**From:**   
**To:**   
**Cc:**   
**Subject:** Heritage NSW - Aboriginal Cultural Heritage (ACH) - EIS - Woolworths Wyong Regional Distribution Centre Expansion (SSD-33701741) (Central Coast)  
**Date:** Thursday, 19 May 2022 5:44:00 AM  
**Attachments:** [image001.png](#)  
[image002.png](#)  
[image003.png](#)  
[image004.png](#)  
[image005.png](#)  
[image006.png](#)  
[image009.png](#)

**Re: Advice on Environmental Impact Statement (EIS) – Woolworths Wyong Regional Distribution Centre Expansion – (SSD-33701741)**

**Woolworths Wyong Regional Distribution Centre Expansion (SSD-33701741) – Review of Environmental Impact Statement**

Subject: **Woolworths Wyong Regional Distribution Centre Expansion (SSD-33701741) – Environmental Impact Statement (EIS)**

Figure 5-4: LPG Jet Fire Radiant Heat Contours

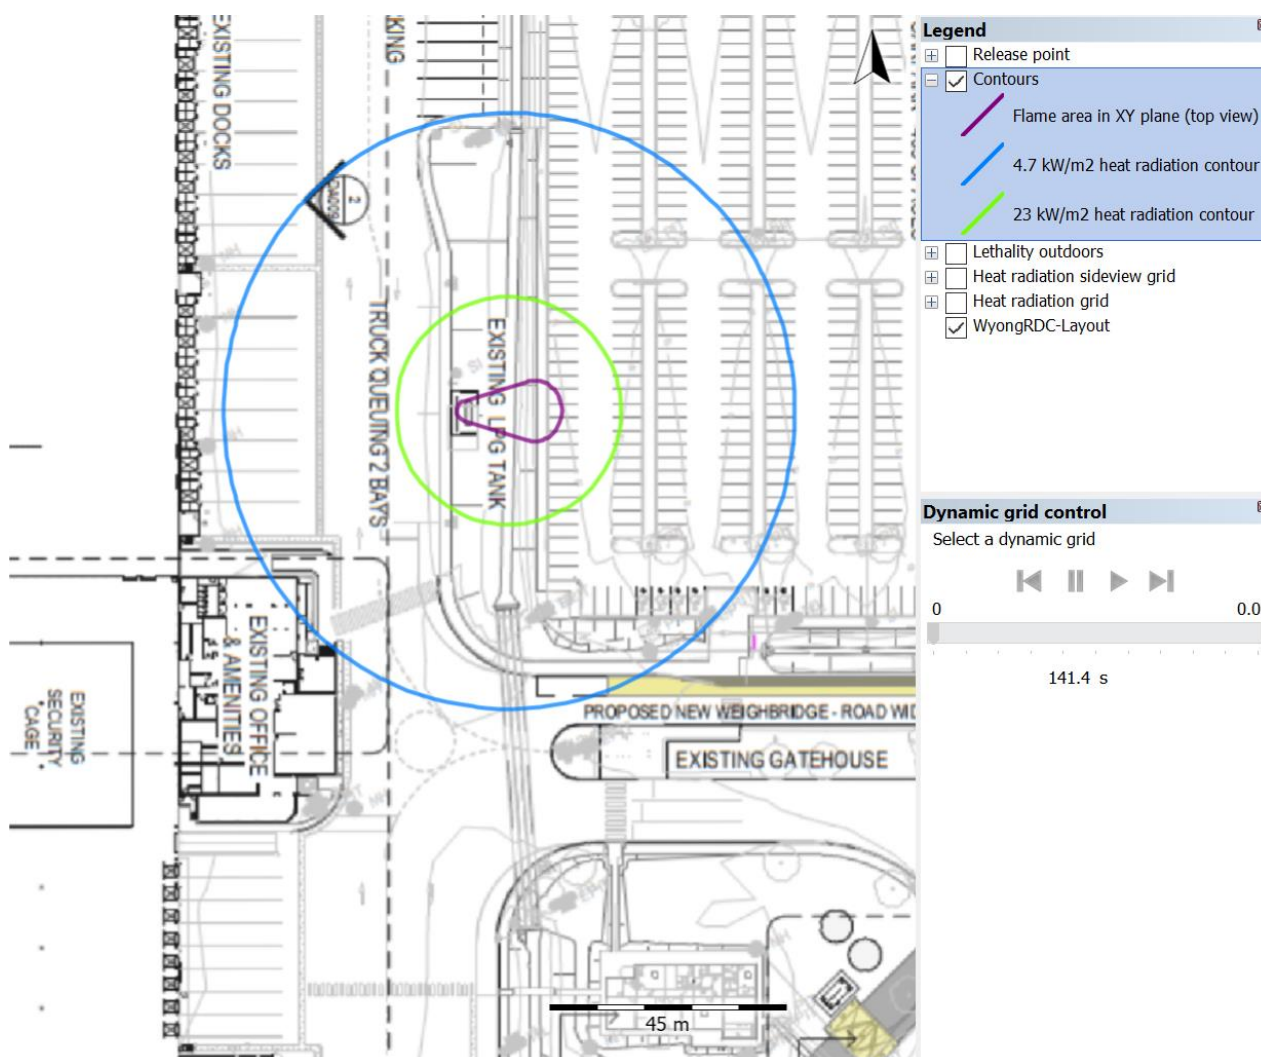
FRNSW note in the PHA when calculating the impacts of Radiant Heat from a Full Warehouse Fire that emitted smoke is used to reduce the average surface emissive power (SEP) and subsequently it would not exceed 23 kW/m<sup>2</sup>. Consideration should be given to the radiant heat emitted by the smoke layer / plume as an emitting body that will increase the SEP.
